Fire Marshal Division

May 11, 2018

**Re: Concrete Supply
243 Progress Drive
Fuquay – Varina, NC 27526**

Application Number 18-50043658

1 LIFE SAFETY PLAN
SCALE: 1/8" = 1'-0"

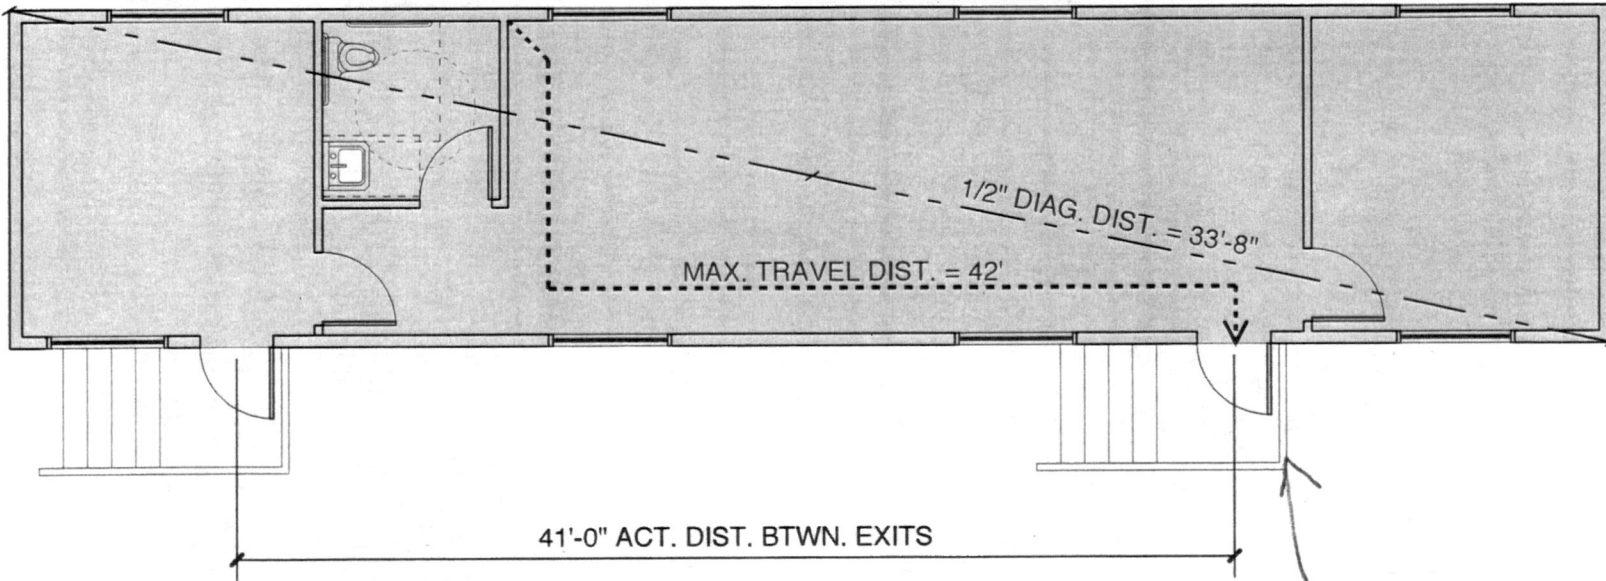
- **906.1 Fire Extinguishers**
 - Fire extinguishers shall be placed in approved locations as indicated on the plan, and verified on the final inspection.
 - The fire extinguishers provided shall have a minimum rating of 2A 10 B: C and shall not be installed higher than 5 feet above the finished floor.
